98, Elmer Road, Middleton On Sea, Bognor Regis
Proposed Extensions & Alterations & Extended Parking Area
Application No. M/114/17/HH

Further to your e.mail communication dated 14th November 2017 I enclose two copies the following amended information as requested in your e.mial.

No. 14/18/01 X

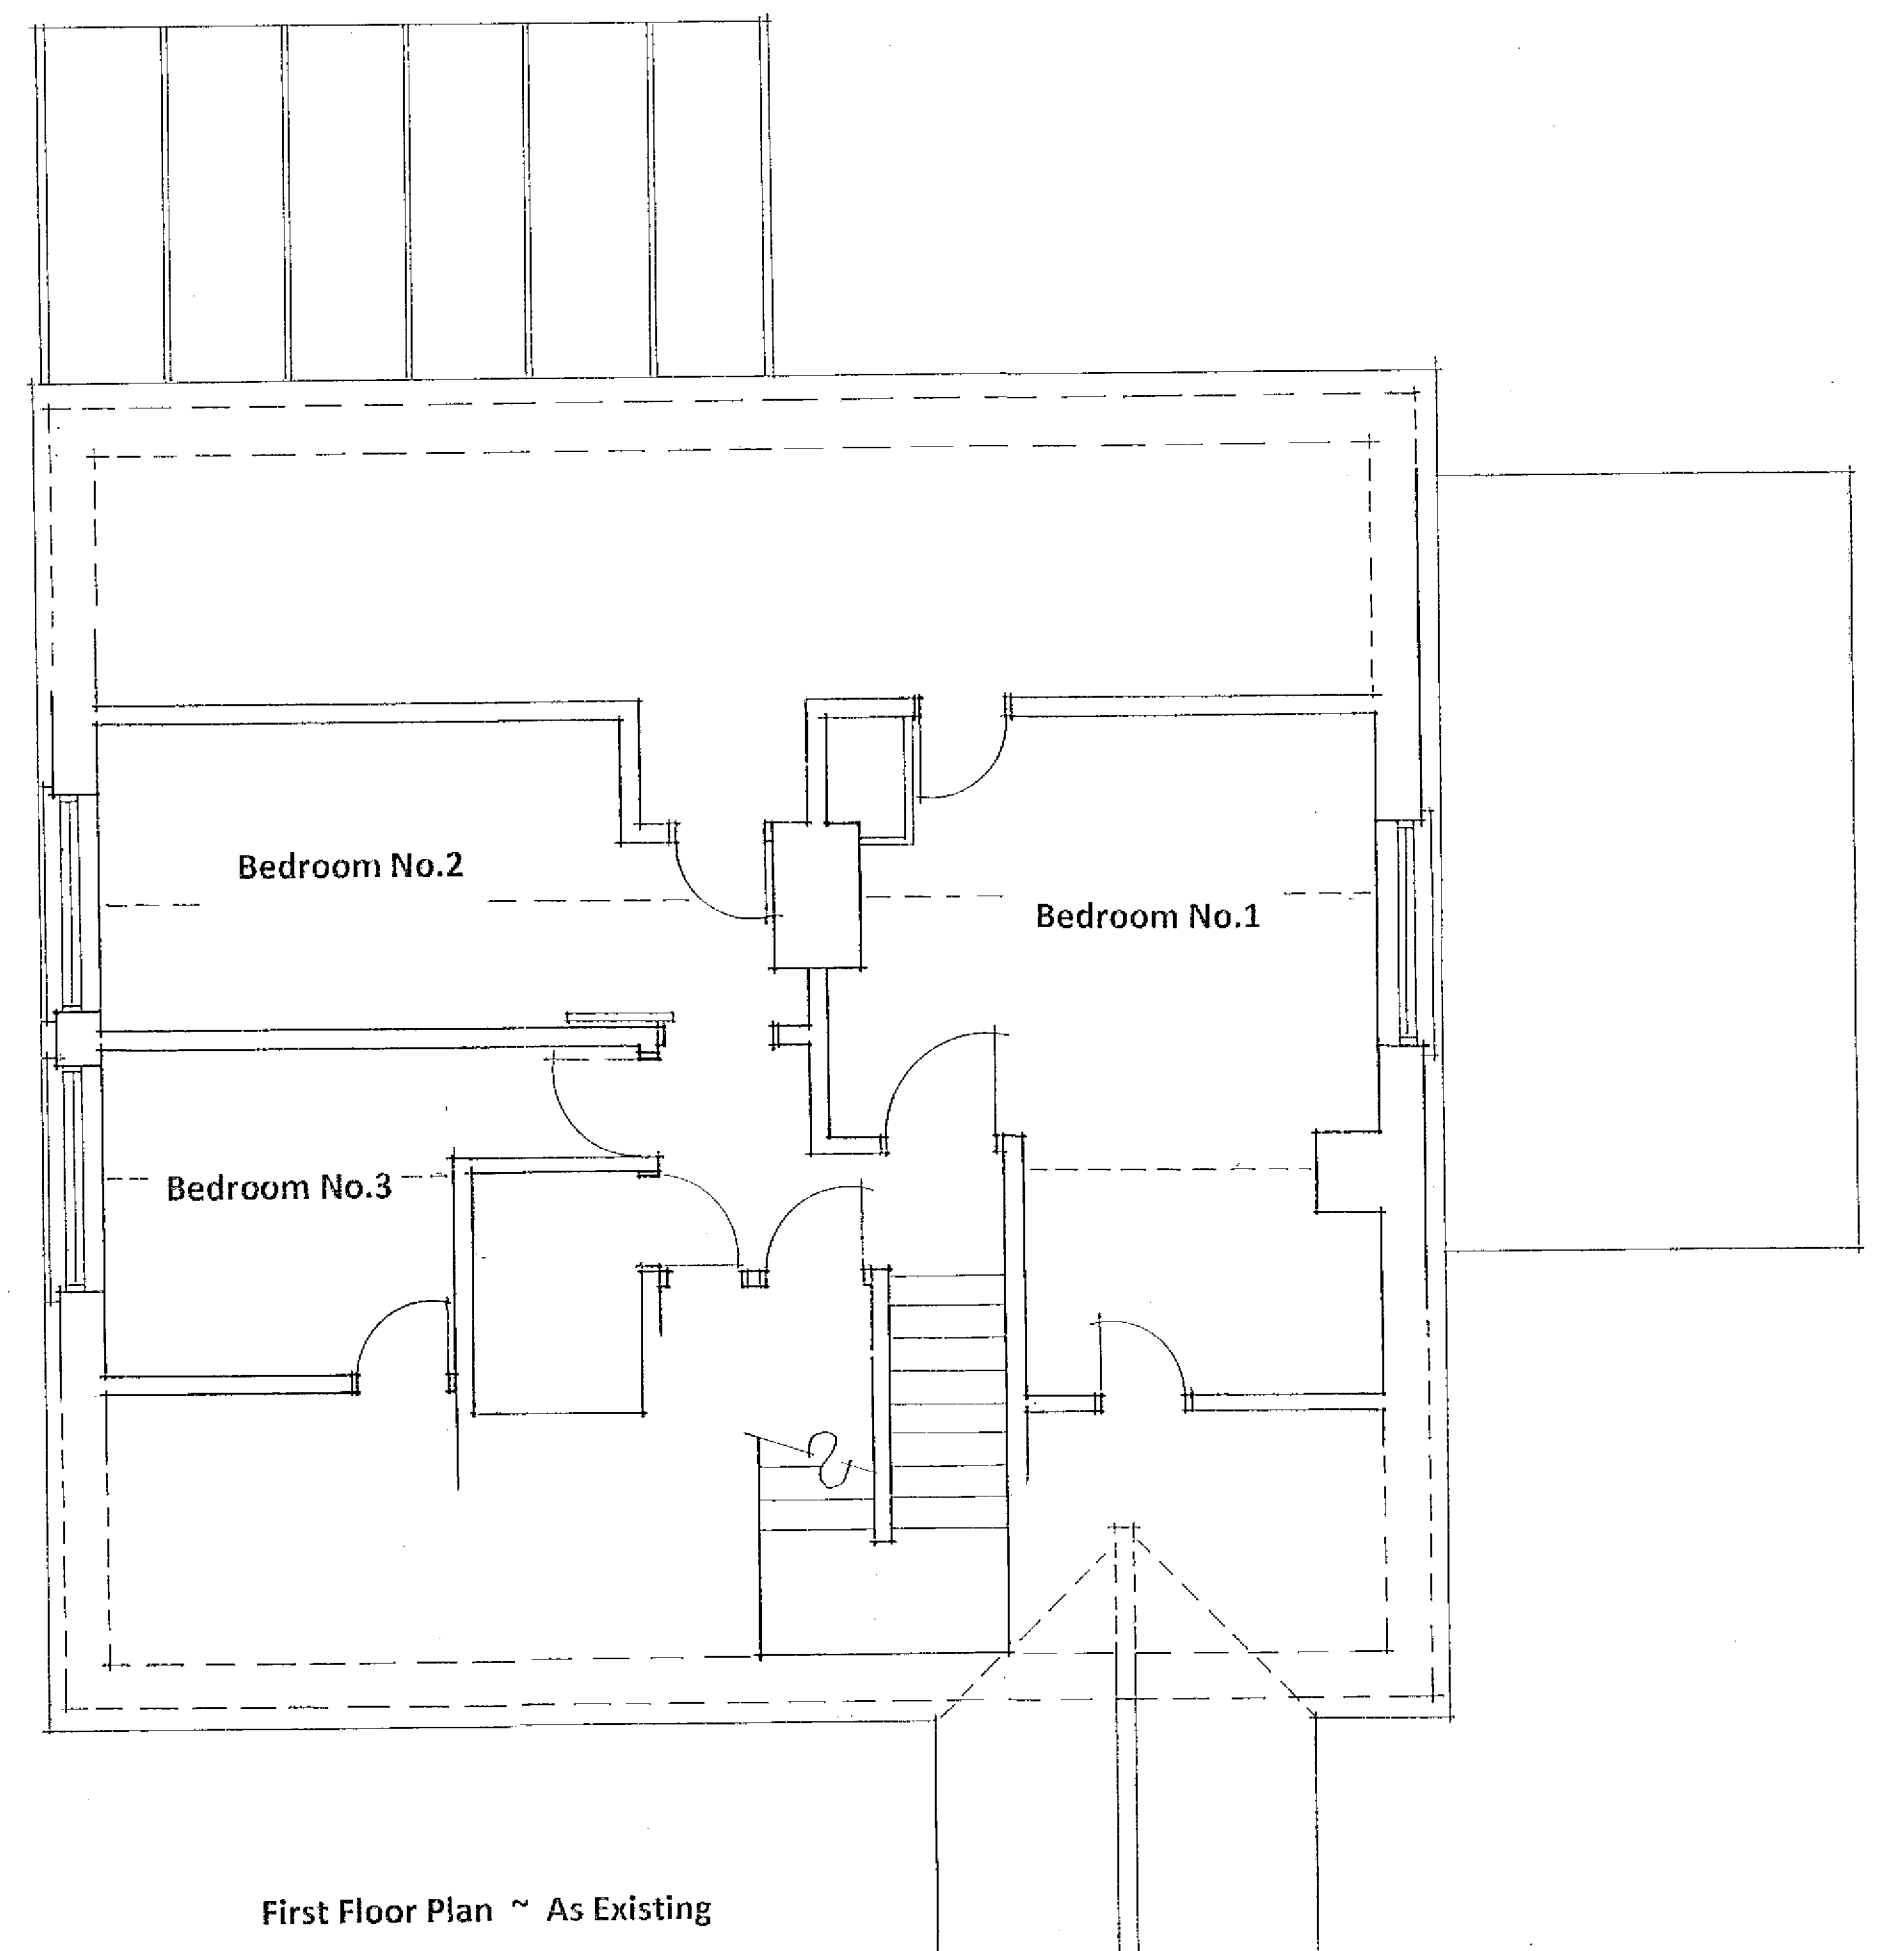
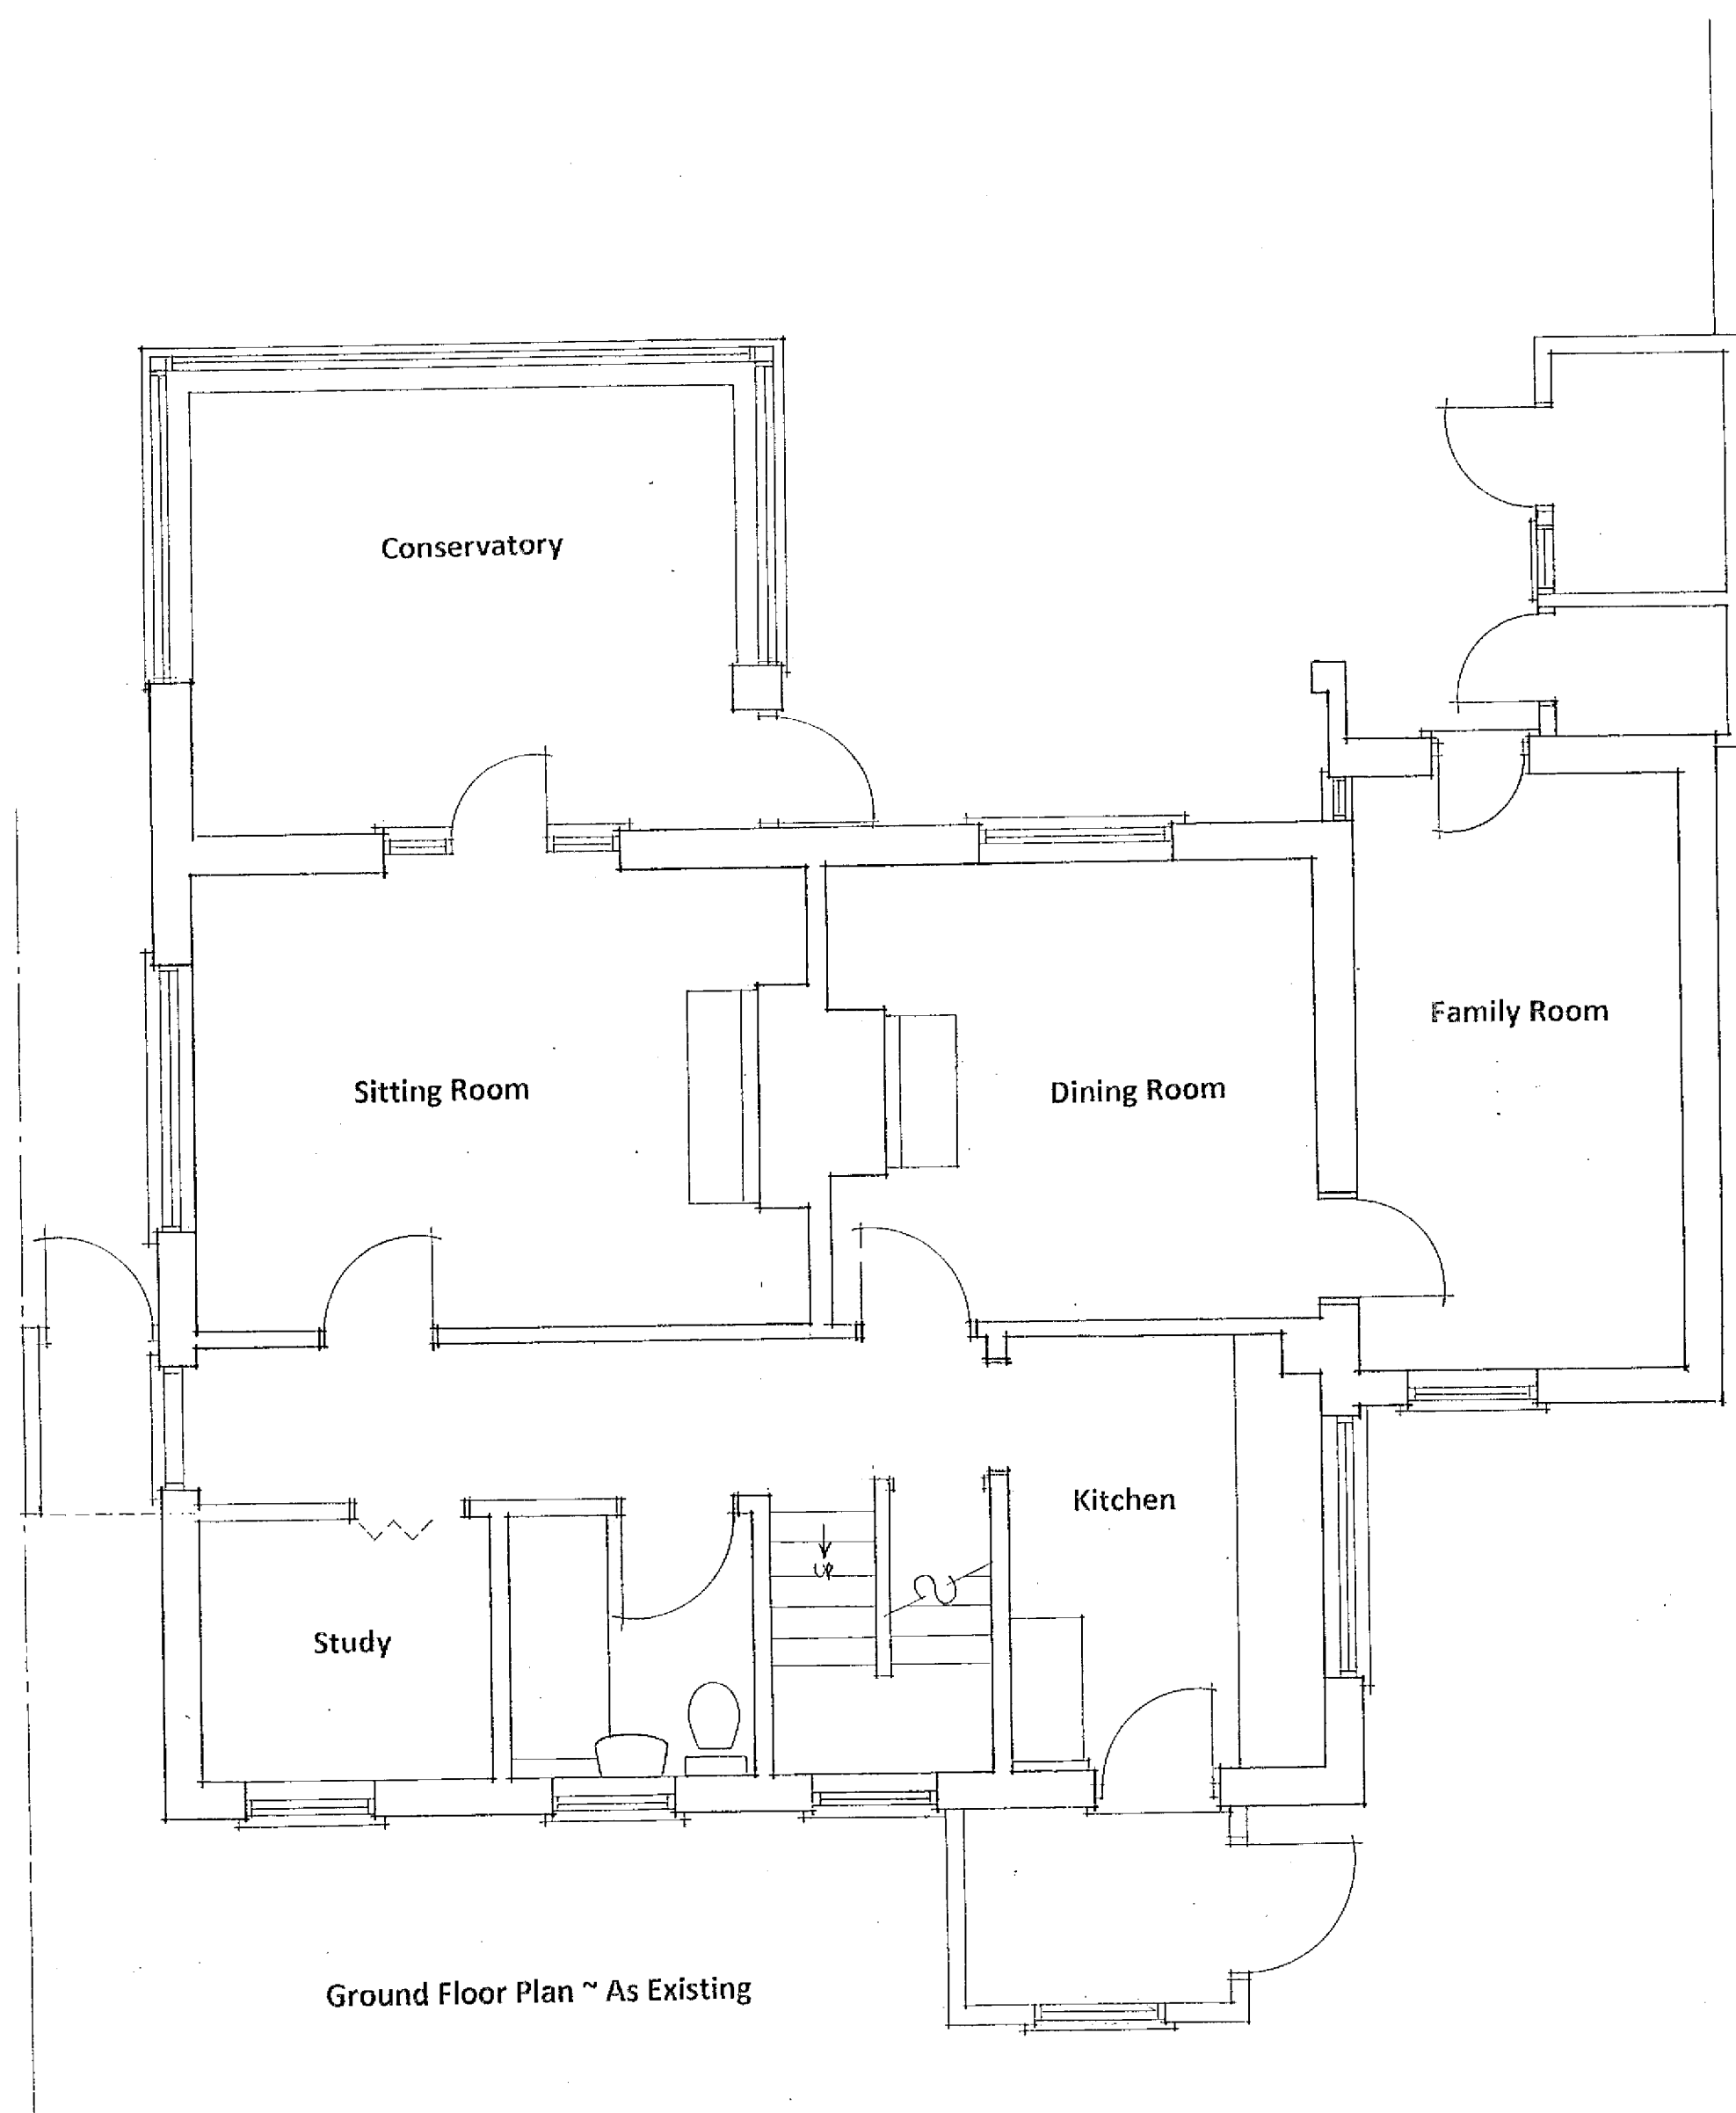
- 1) Block Plans showing distances to boundaries.
- 2) Proposed elevations with the correct orientations added.
- 3) Existing Ground Floor Plan amended with the staircase window shown.
- 4) Proposed ground/first floor plan amended with the staircase window shown.
